WEST SUSSEX COUNTY COUNCIL CONSULTATION

TO:	Arun District Council FAO: Simon Davis
FROM:	WSCC - Highways Authority
DATE:	29 July 2020
LOCATION:	Land west of Fontwell Avenue, Eastergate, PO20 3RX
SUBJECT:	BN/50/20/PL Demolition of existing structures onsite & erection of 42 No. dwellings with access, parking, landscaping & associated works. This application is a Departure from the Development Plan. More information received.
RECOMMENDATION:	More Information

Drawing Number	Revision
29662A_503	C

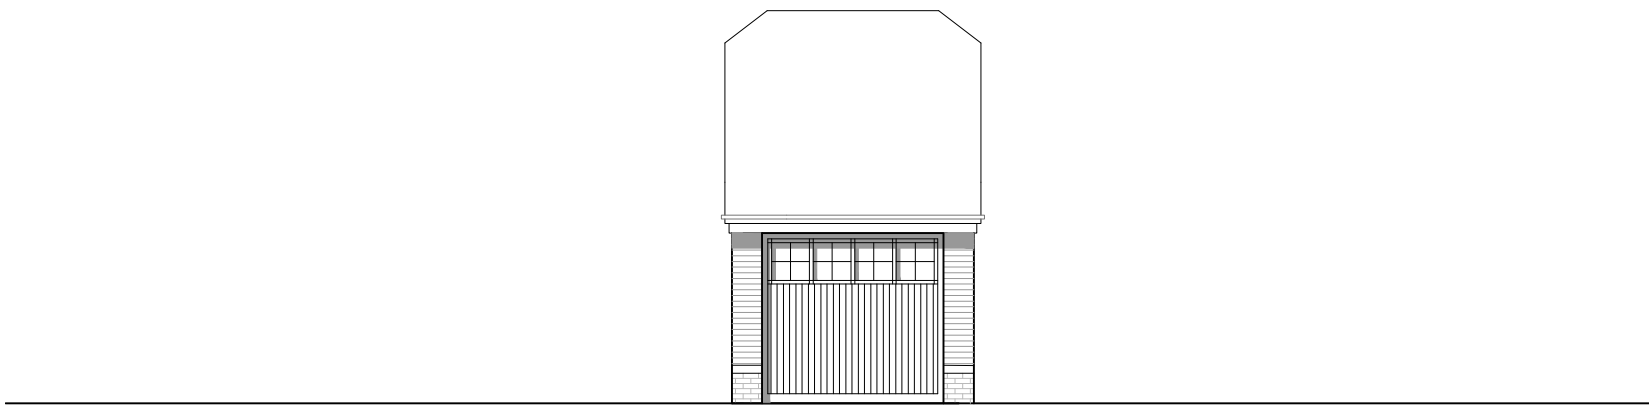
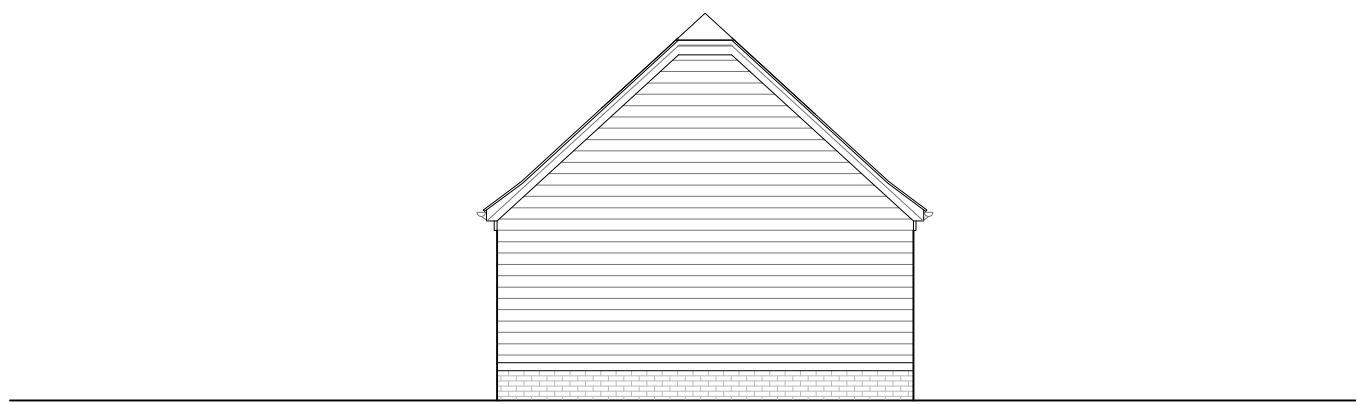
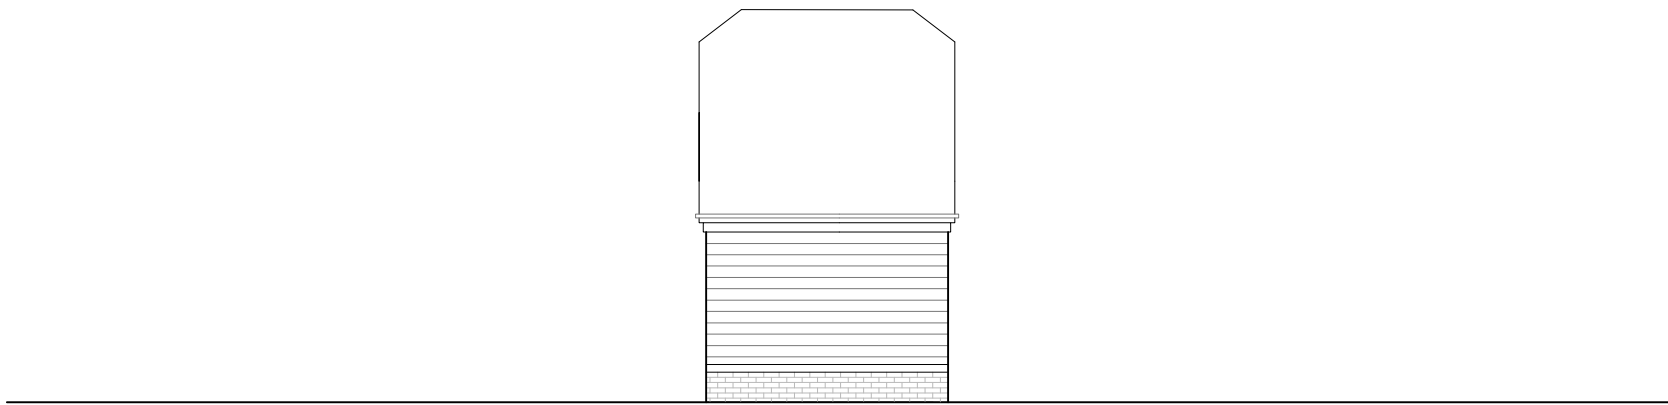
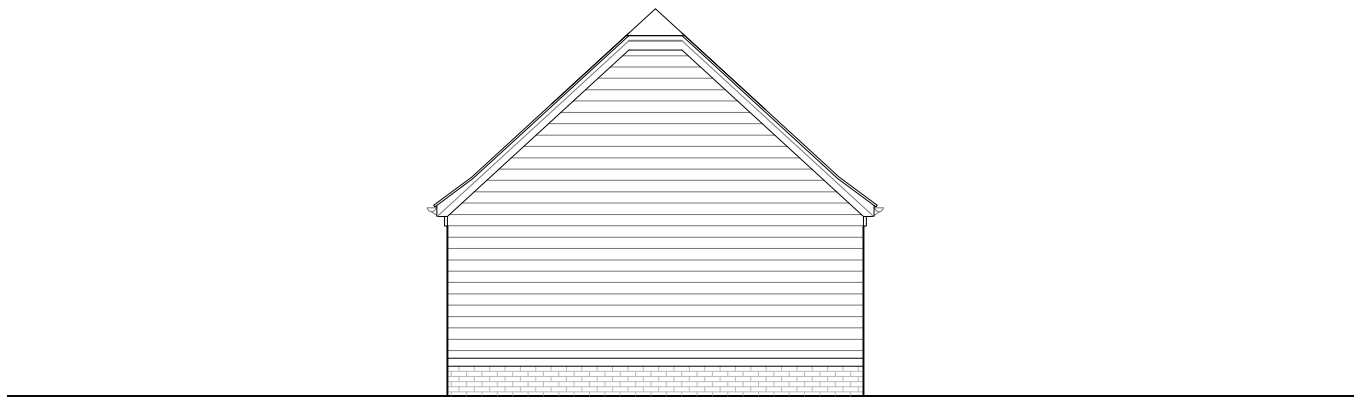
Amended Garage Floor Plans drawing no. 29662A_503 Rev C. has been provided. These indicate that the single garages will be internal dimension of 3m by 5.1m. These should be extended to 3m by 6m in order to count toward an allocated parking space (and also provide internal space for bicycle storage). This may alter the site/block plans slightly but it is anticipated that sufficient space will remain available where previously spaces fronting garages have been shown.

The garage floor plans do show substandard length and these should be amended to meet with local guidance (3m by 6m). In terms of the DfS forms, further clarification and justification should be provided as per the Highway Design/ Agreements Project Manager comments outlined above and the forms re-sent in Microsoft Word format.

Site Block Plan

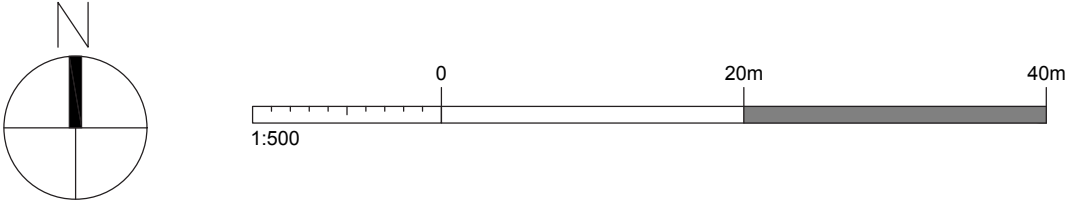
It is noted that the amended Site Block Plan drawing no. 29662A_100 Rev V. shows detail of a 2m wide footpath pedestrian link in the north-western corner of the site that will provide a link to Level Mare Lane. Whilst Level Mare Lane does not feature a segregated footway, the existing traffic flows on Level Mare Lane are anticipated to be low and it is therefore considered acceptable in this case that the link for pedestrians is provided without any further supporting pedestrian infrastructure on Level Mare Lane.
